Appeal Decision

Appeal Ref: APP/R5510/D/23/3322520

111 Long Lane, Ickenham UB10 8QS

Dwg no:	Revision.	Date:
0131-PR-10	D2	04.03.2021
Scale:	Drawn by:	Checked by:
1:100@a3p

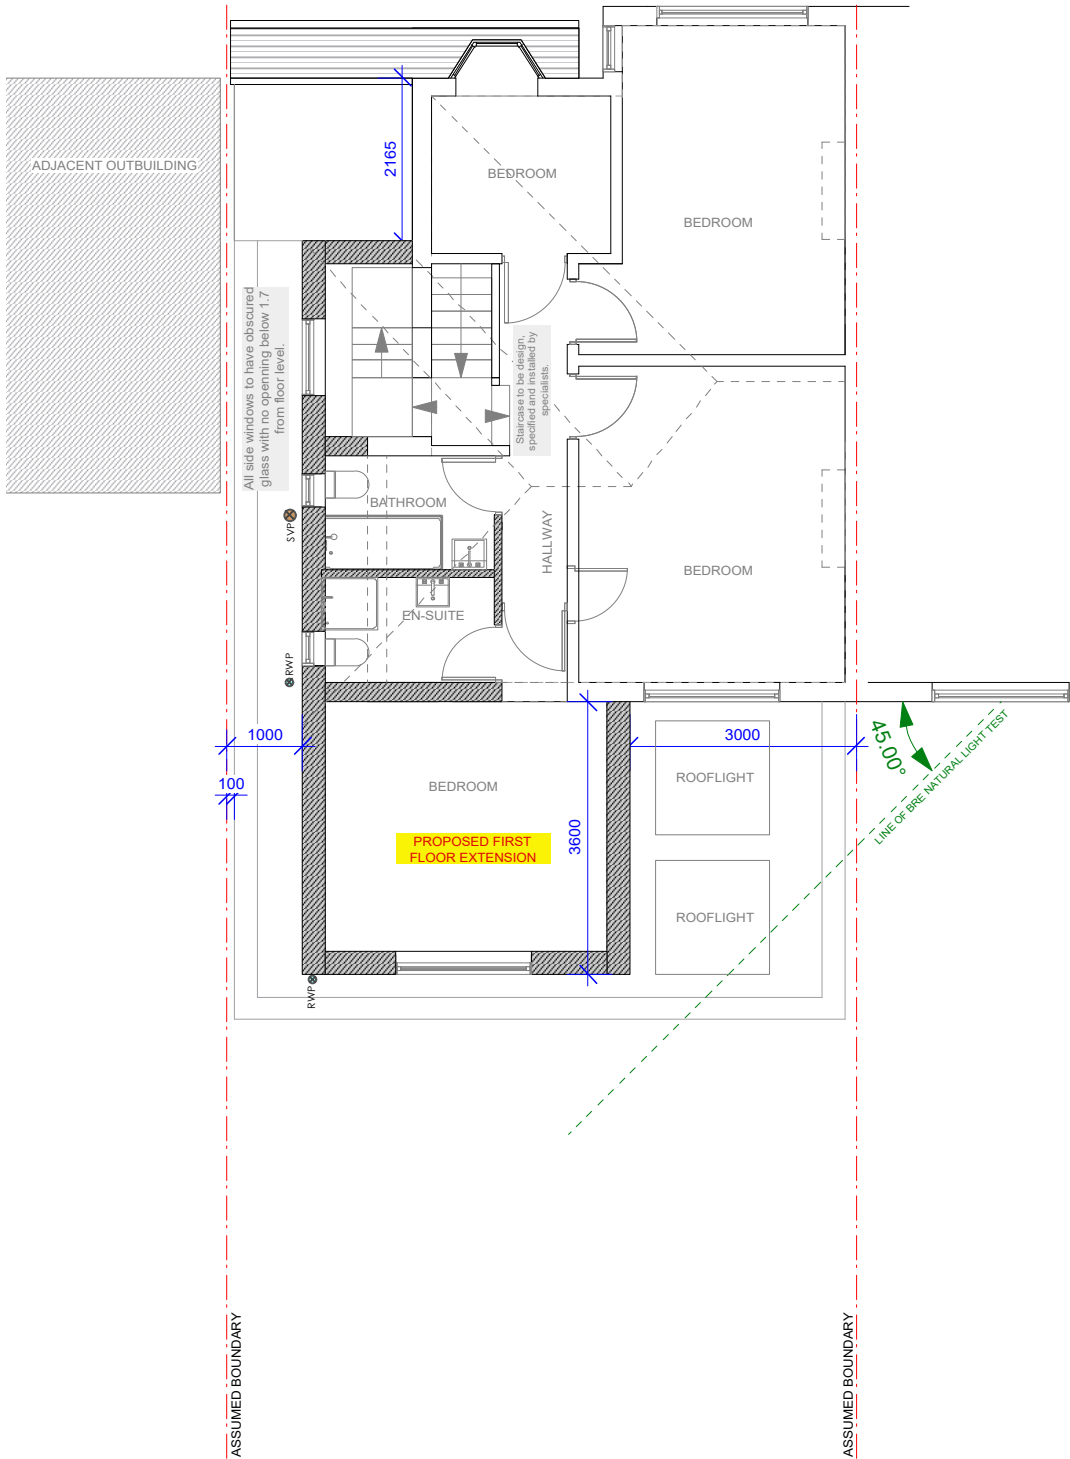
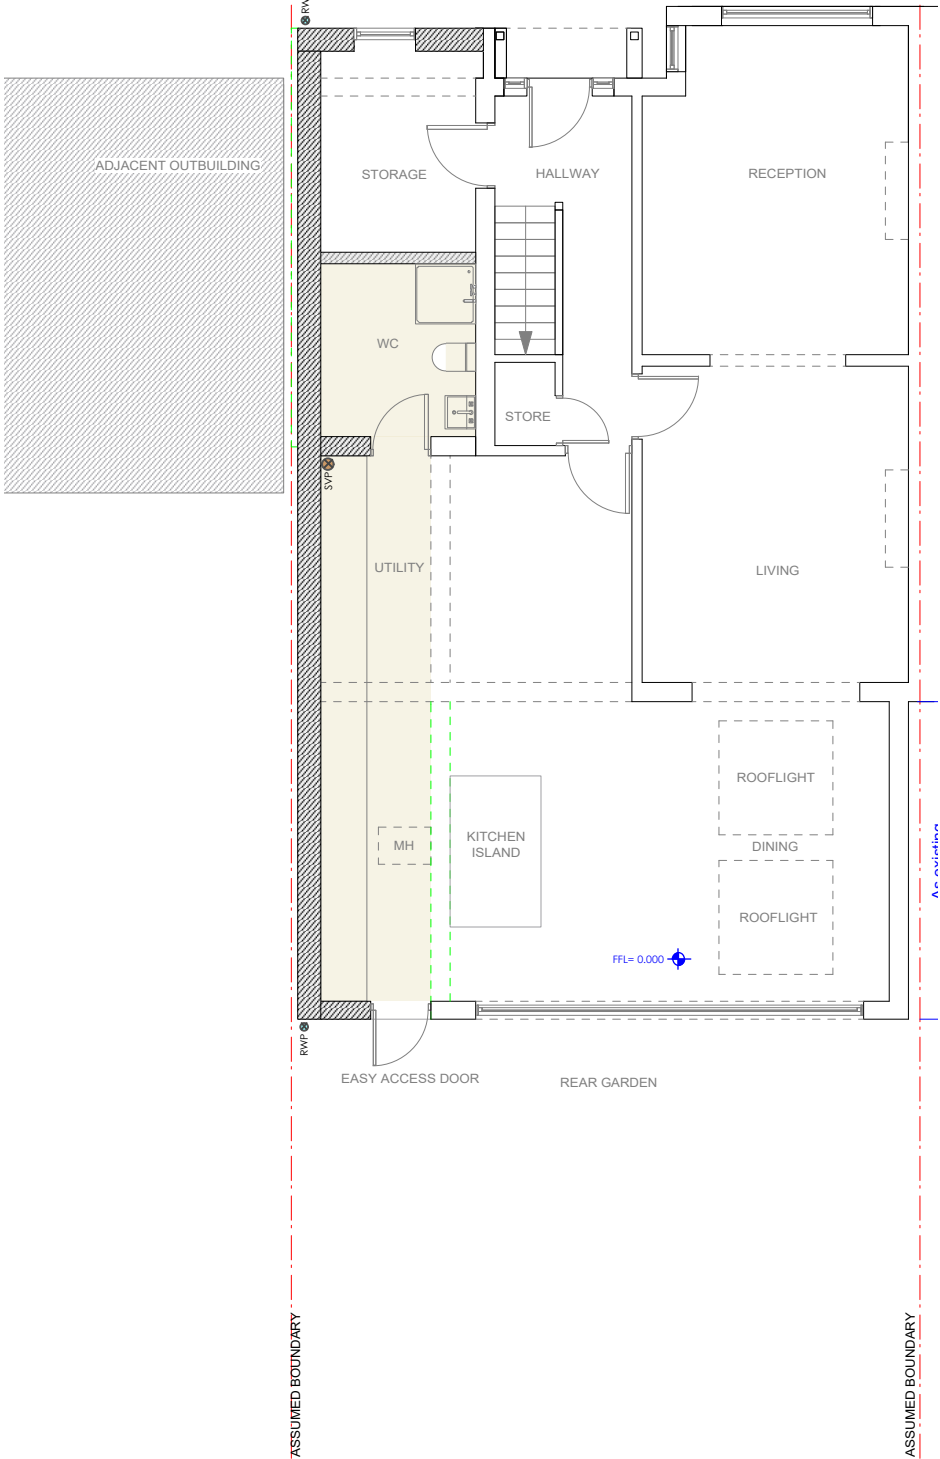
12. The Council have drawn my attention to the elevation and floorplan on the western elevation as they are not consistent with regard to the upper floor windows. Corrected plans can be secured by condition.

23. For the reasons given above, I have imposed a further condition requiring an amended plan for window details on the upper floor on the western elevation. This is reasonable and necessary to define the terms of the permission and to have an acceptable effect on the living conditions of the existing and neighbouring occupiers and the character and appearance of the area.
